From: Laura Gibbons
Sent: 24 June 2019 09:39
To: Planning.Responses <Planning.Responses@arun.gov.uk>
Cc: Juan Baeza <Juan.Baeza@arun.gov.uk>
Subject: RE: Planning Consultation on: F/11/19/PL

Engineers Comments Regarding Surface Water Drainage

APPLICATION F/11/19/PL

Description of Works: Construction of agricultural barn with flexible storage use (B8 Use Class) with ancillary office space

Indicative Drainage Layout
Restricted Discharge

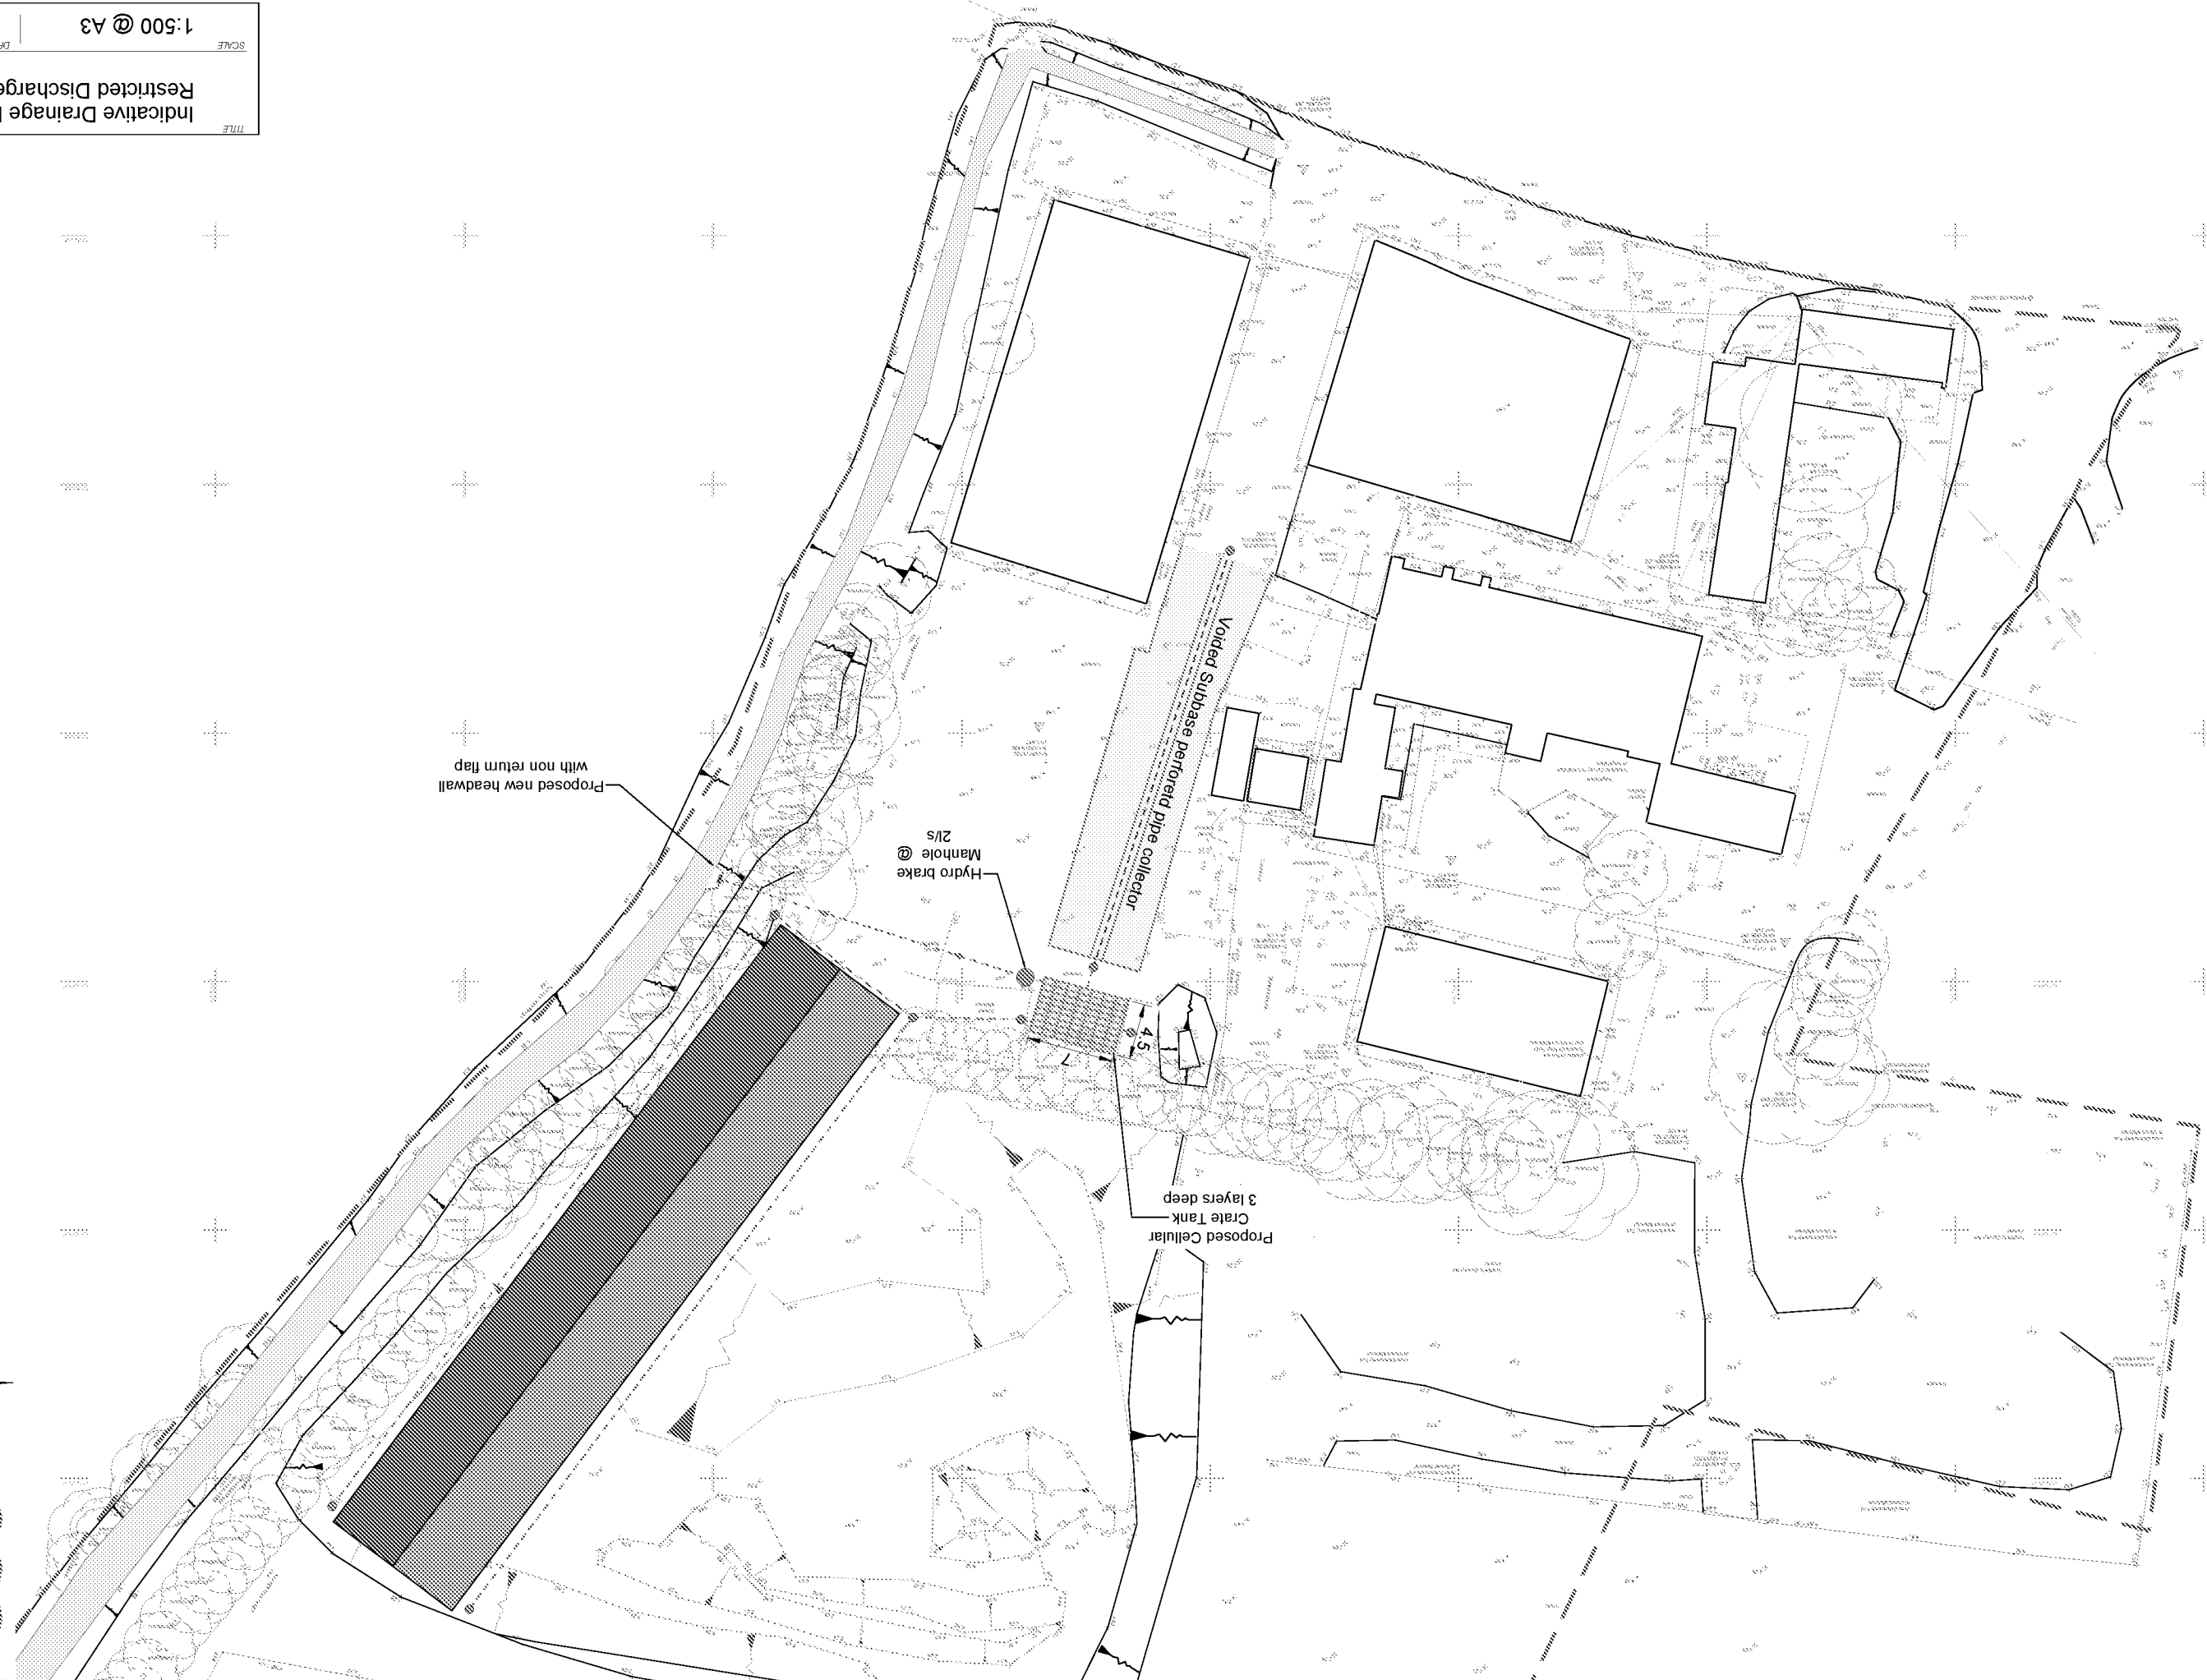
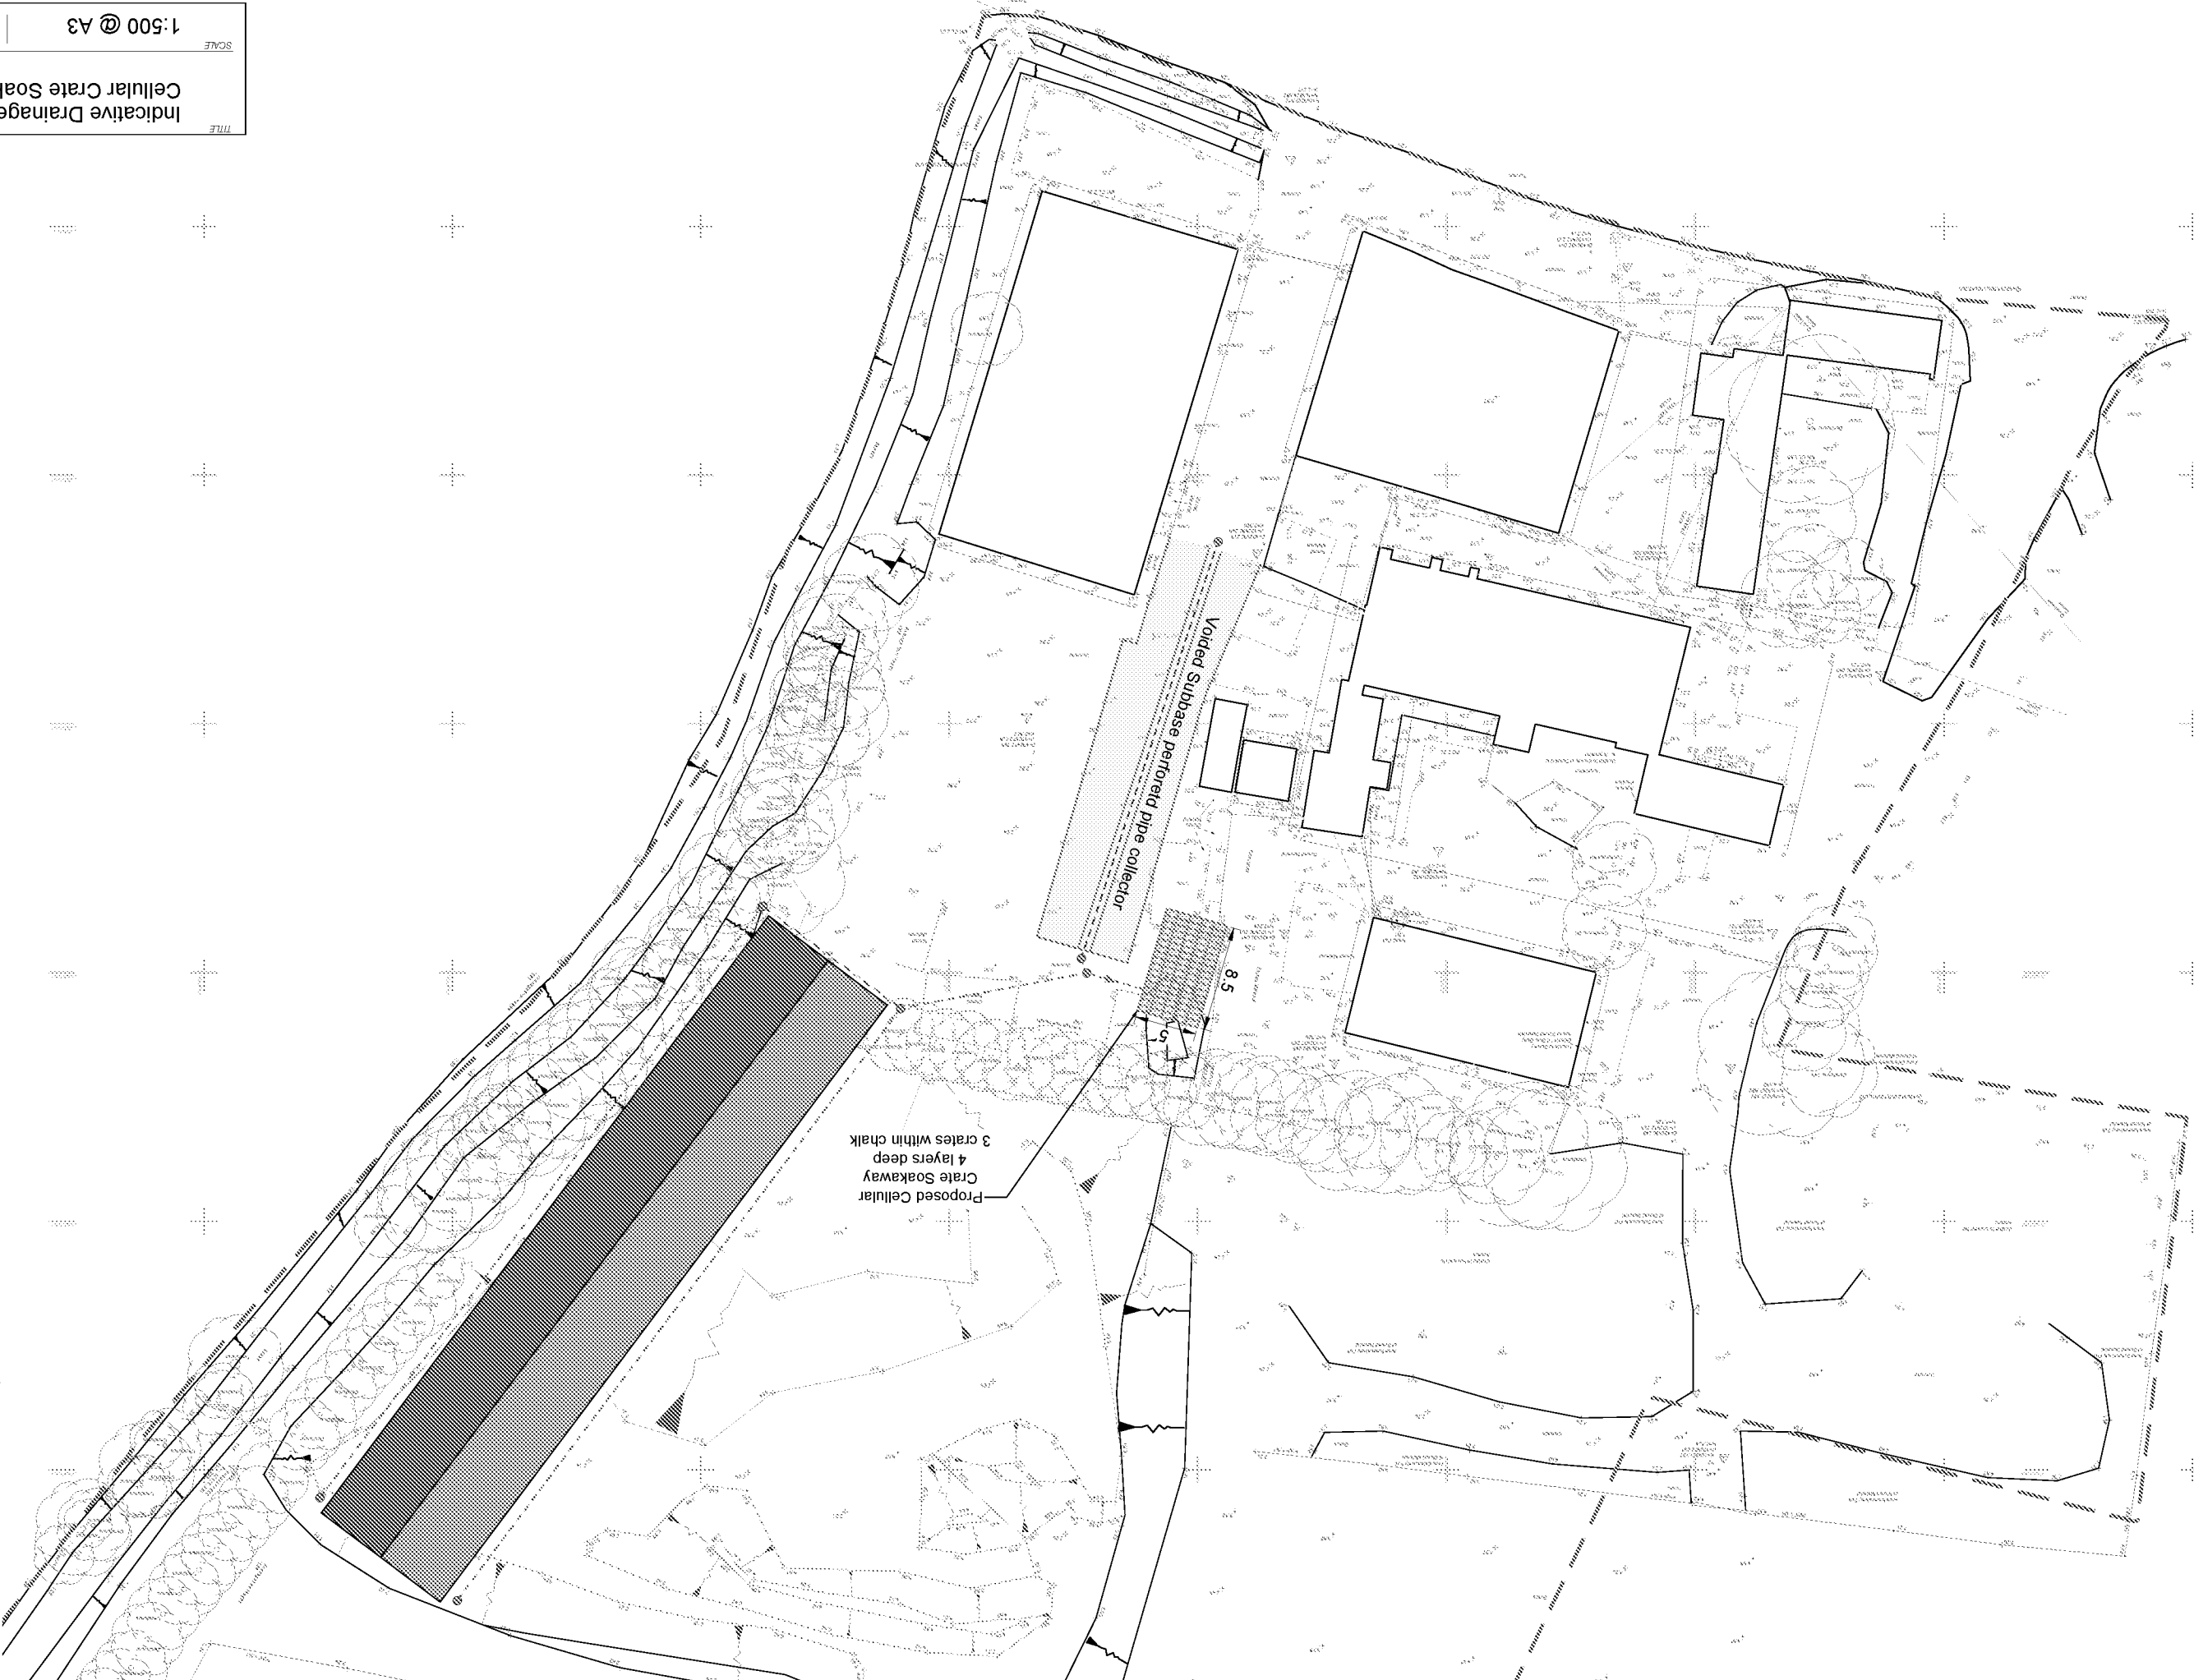
The application has areas within flood zone 1, 2 and 3. The Environment Agency should therefore be consulted. Surface water drainage features should not be located within flood zone 3.

There is a watercourse in close proximity to the site. Surface water drainage should be carefully considered with infiltration fully investigated. If you are minded to approve this application please apply the following conditions:

"Development shall not commence, other than works of site survey and investigation, until full details of the proposed surface water drainage scheme have been submitted to and approved in writing by the Local Planning Authority. The design should follow the hierarchy of preference for different types of surface water drainage disposal systems as set out in Approved Document H of the Building Regulations, and the recommendations of the SuDS Manual produced by CIRIA. Winter groundwater monitoring to establish highest annual ground water levels and winter Percolation testing to BRE 365, or similar approved, will be required to support the design of any Infiltration drainage. No building / No part of the extended building shall be occupied until the complete surface water drainage system serving the property has been implemented in accordance with the agreed details and the details so agreed shall be maintained in good working order in perpetuity."
